The Planning Inspectorate  
M23 junction 10 / A3 Wisley Interchange

I am the County Commissioner for Girlguiding Greater London West and we own Heyswood Campsite which is being affected by the M25 junction 10 / A3 Wisley Interchange Improvement Plan.

Our Response to the DCO

DO NOT SCALE

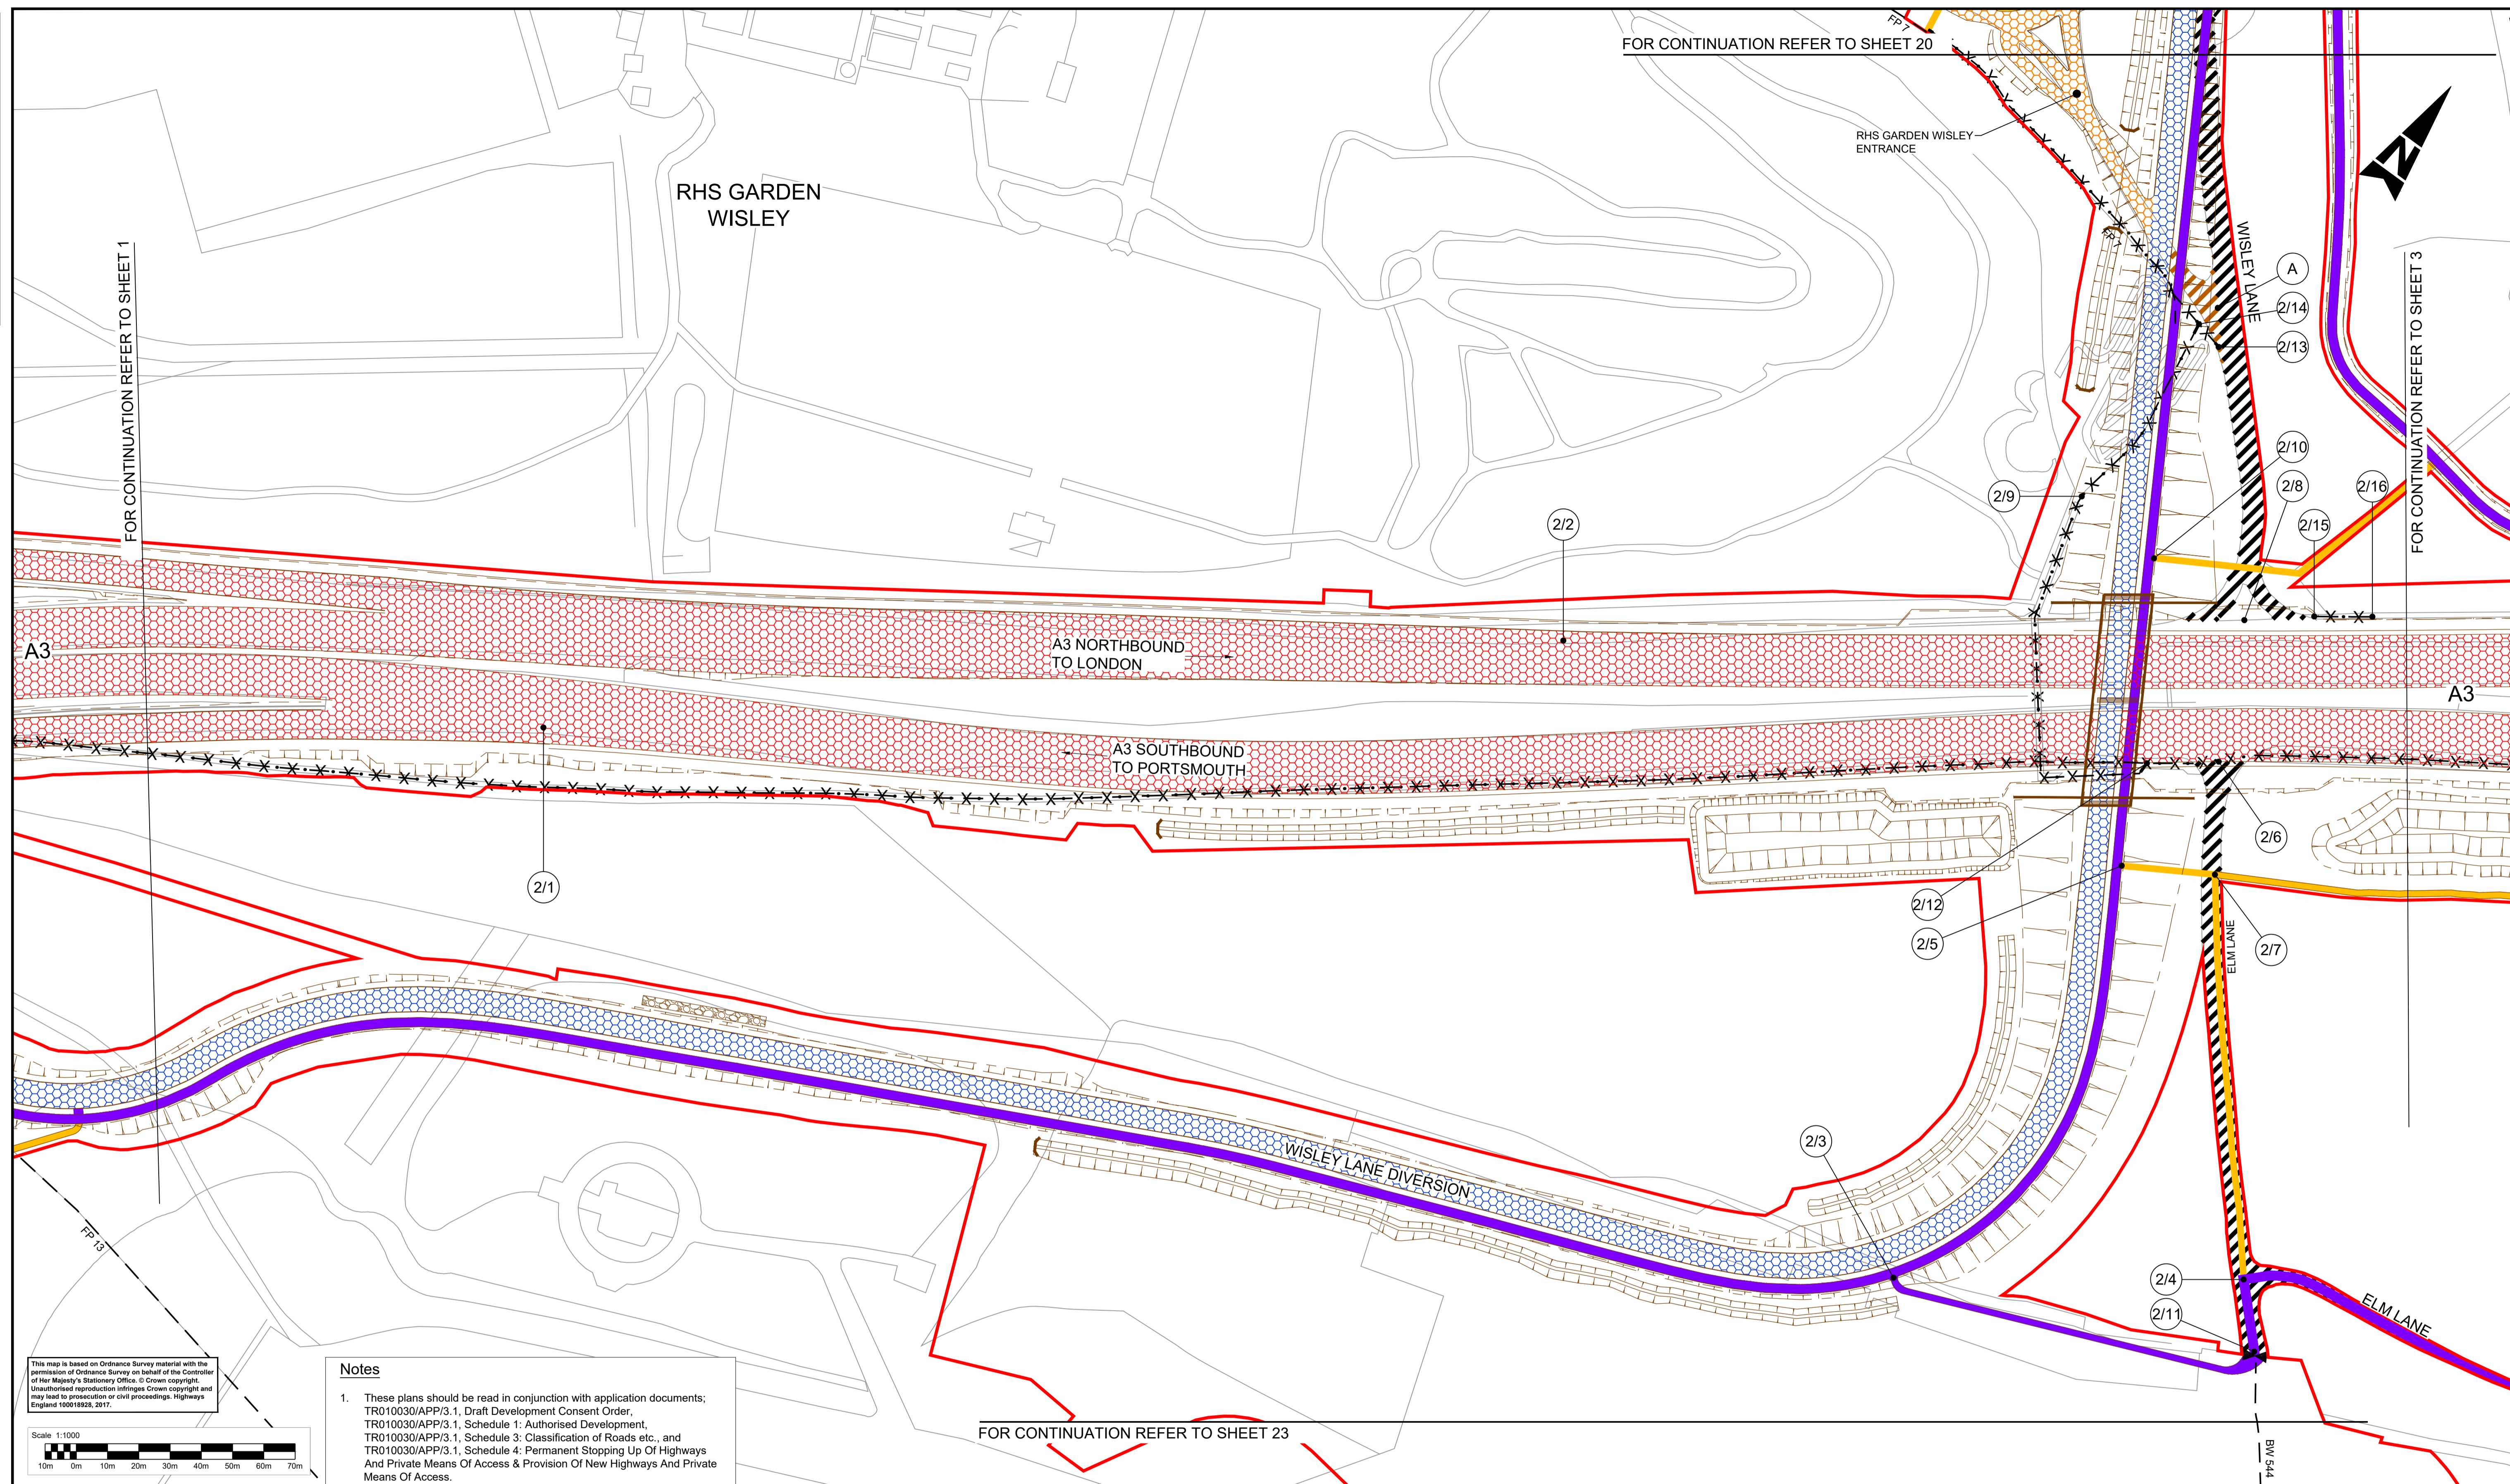
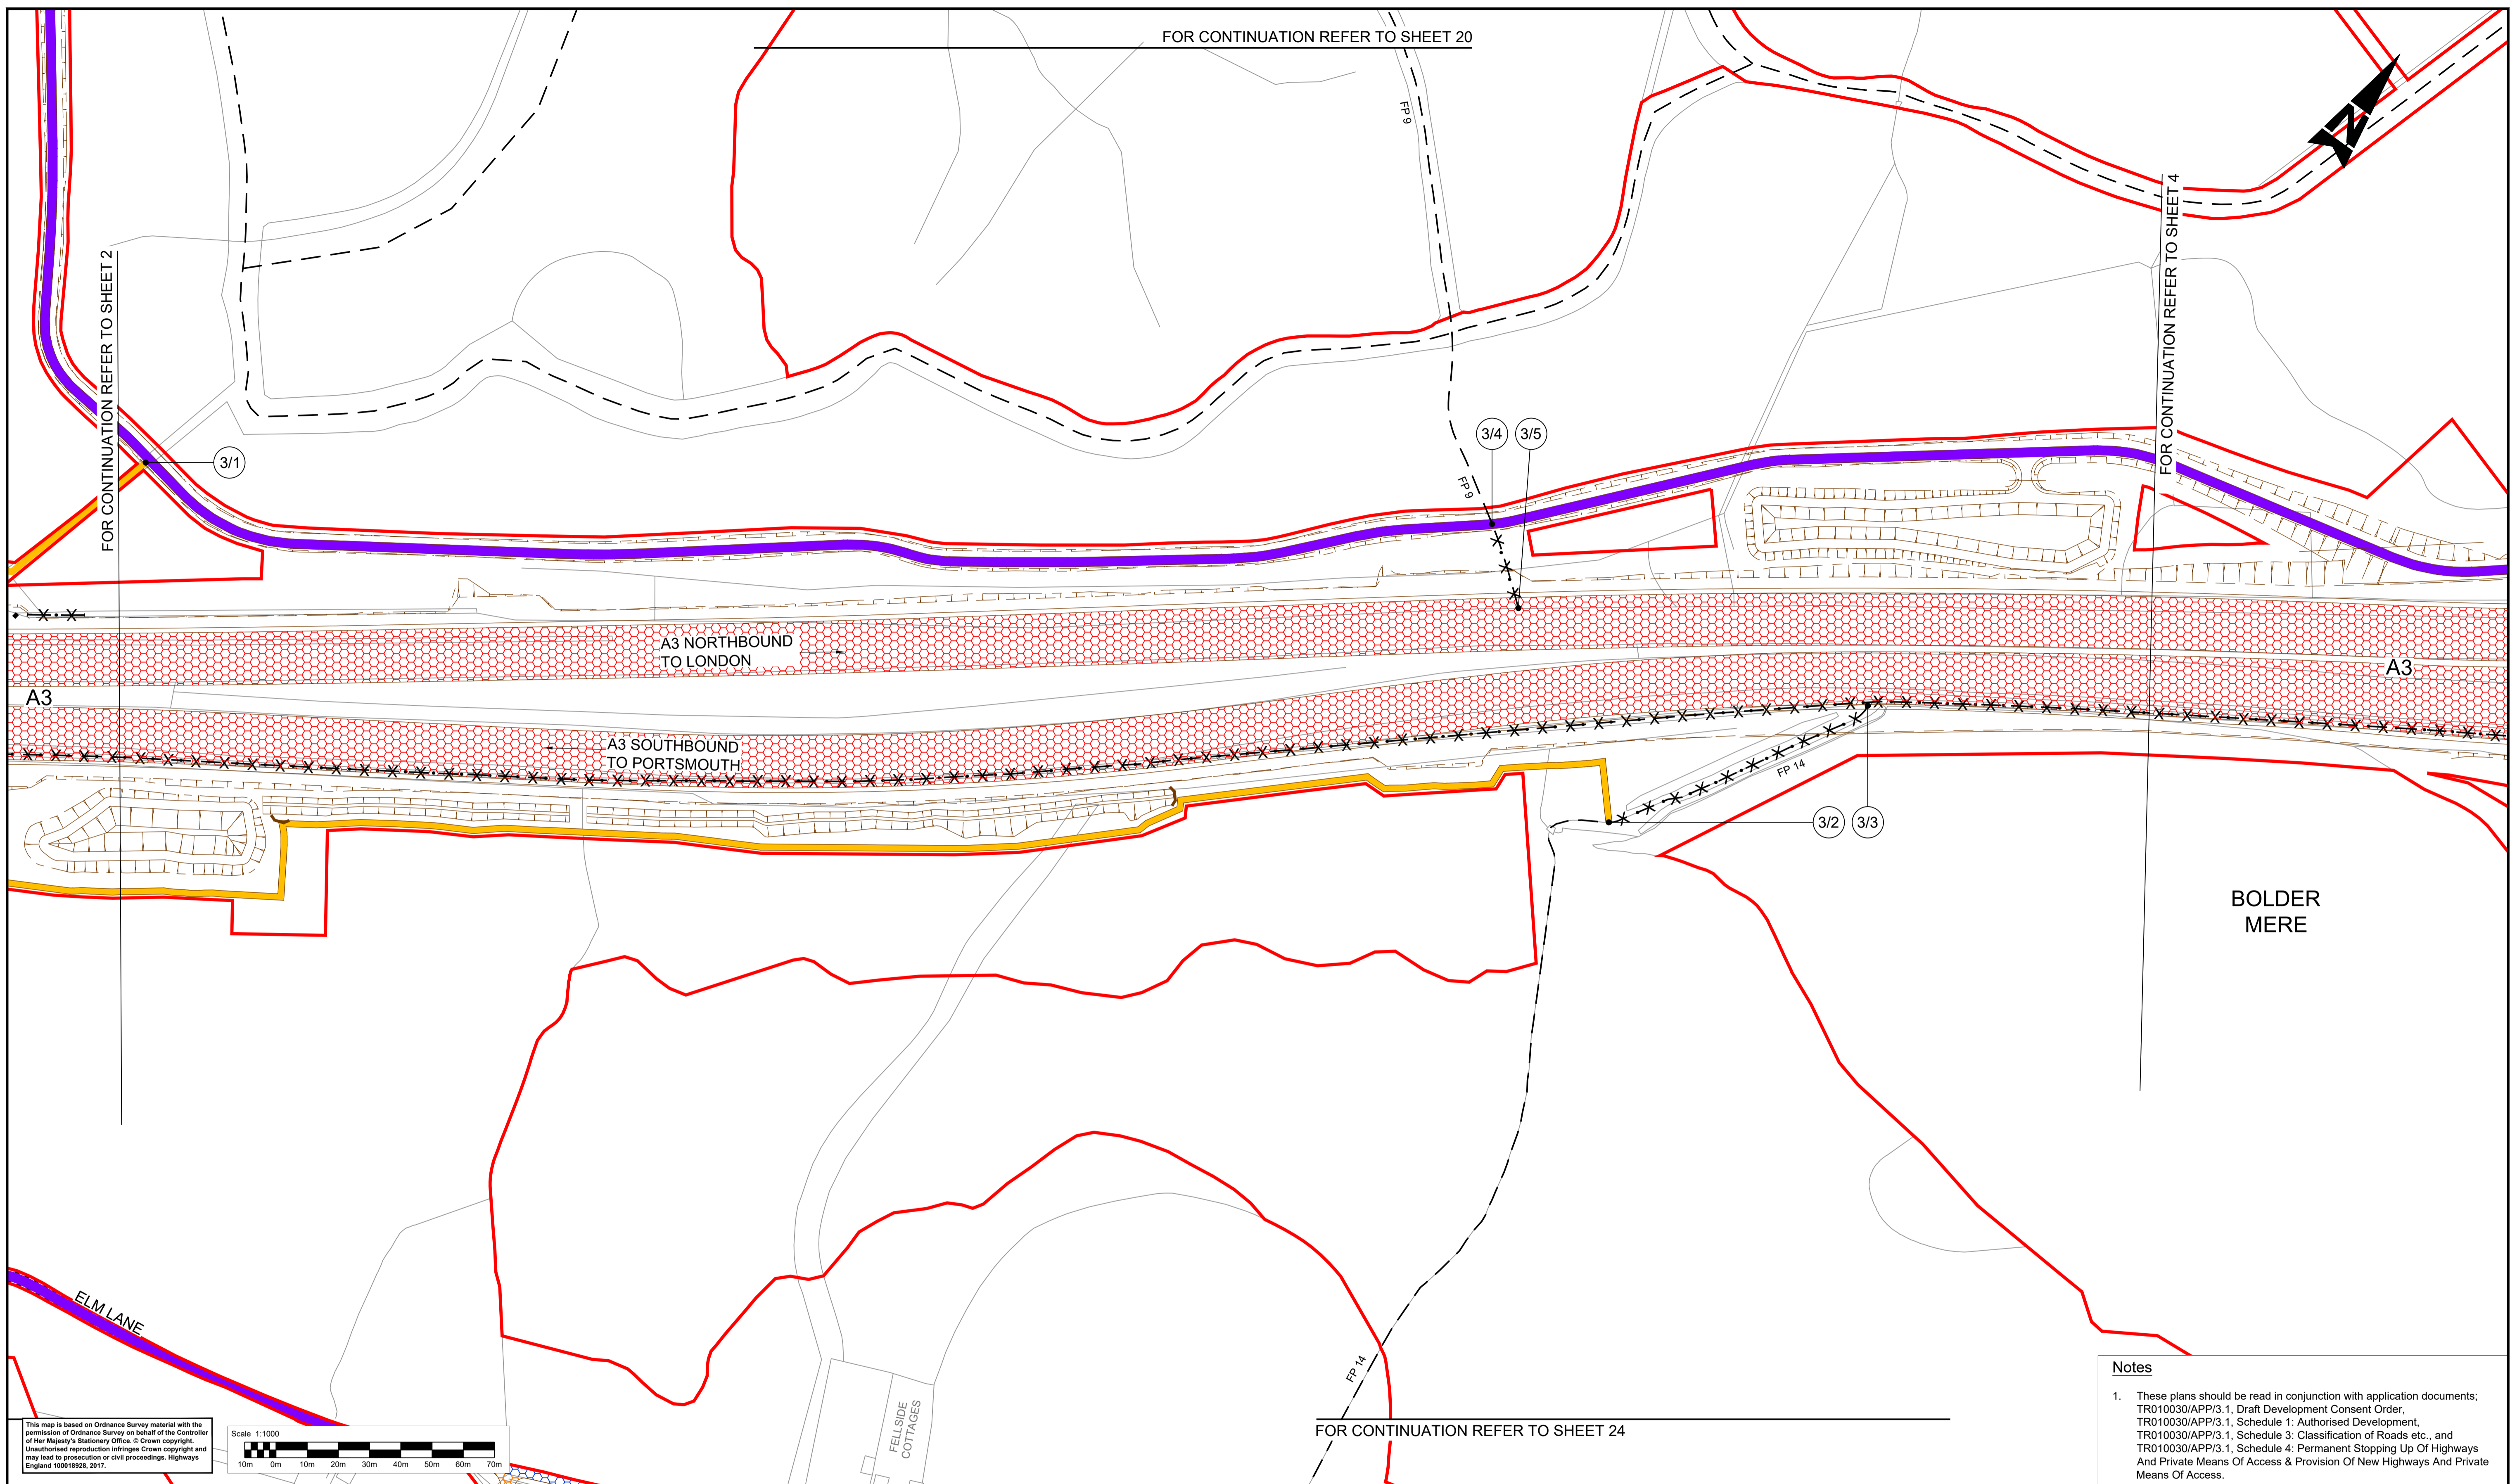
- The map showing the new road proposal across our land is inaccurate. It is inaccurate in that the current track is inaccurately marked. This makes it difficult to be sure where the new road is proposed.

- The map also shows, fencing on both sides of this road, yet when we queried this with Highways England and Atkins, they indicated that they had not intended this to be the case so they were not sure why this is showing.

- We have asked for the width of the track to both be minimised and as close to the current track as possible to ensure that trees are not felled unnecessarily. Currently the mature sweet chestnut that is of regional significance is showing as being felled as it is within the new road proposal.

- We have asked for the security gates at the east end of the site to be moved to the boundary as we will continue to need to access buildings alongside our eastern boundary.

- There are a number of symbols on the maps that are not included in the legend and we have asked Atkins/HE for clarification e.g. triangle with CO2, blue circles.

- We have two cess pits on our site near the A3, which service all the buildings on site, and it is still unclear whether these are within the land affected by the DCO or not.
